City of Portland, Maine - Building or Use Permit Application
 389 Congress Street, 04101 Tel: (207) 874-8703, Fax: (207) 874-8716

Permit No: 06-0914	Issue Date:	CBL: 388A B007001
------------------------------	--------------------	-----------------------------

Past Use: Single Family Home	Proposed Use: Single Family Home/ install a 16' x 32' inground pool	Permit Fee: \$219.00	Cost of Work: \$21,145.00	CEO District: 5
Proposed Project Description: install a 16' x 32' inground pool		FIRE DEPT: <input type="checkbox"/> Approved <input type="checkbox"/> Denied	INSPECTION: Use Group: Type	
		Signature:	Signature:	
PEDESTRIAN ACTIVITIES DISTRICT (P.A.D.)				
Action <input type="checkbox"/> Approved <input type="checkbox"/> Approved w/Condition <input type="checkbox"/> Denied				
		Signature:	Date:

Dept: Zoning **Status:** Approved with Conditions **Reviewer:** Mike Nugent **Approval Date:** 06/30/2006
Note: **Ok to Issue:**
1) Must comply with Section 14-432 of the Zoning Reg.

# Grecian 16' x 32'

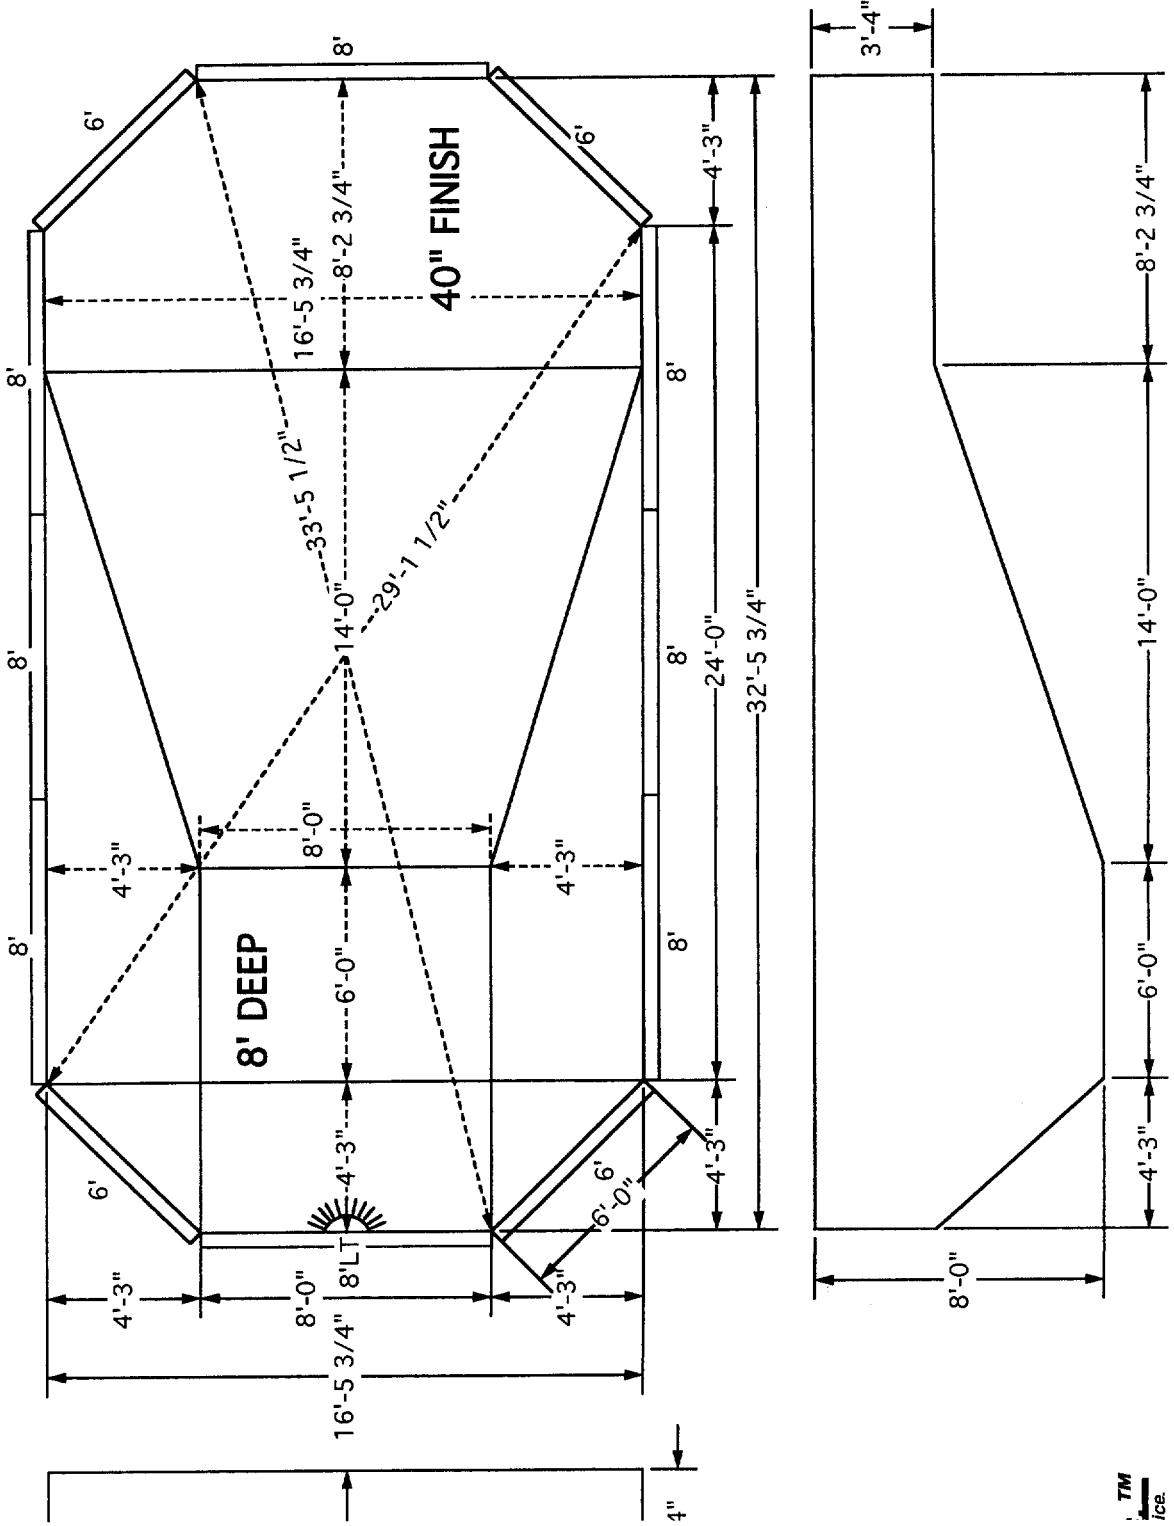
Dept: Building **Status:** Approved with Conditions **Reviewer:** Mike Nugent **Approval Date:** 06/30/2006
Note: **Ok to Issue:**
1) The applicant advises that there is one door from the fhouse into the pool area. This will be alarmed.
This alarm must comply with Section AG105.2.9(2)
2) Applicant advises that the entire yard is being surrounded with a 6' stockade fence. The 6' gate on the right side has no latch on the "public" side.
This gate must be self closing

Comments:
6/30/2006-mjn: Called owner/Left message and need info regarding gate acces/latch etc, as well as protection fo the back door.
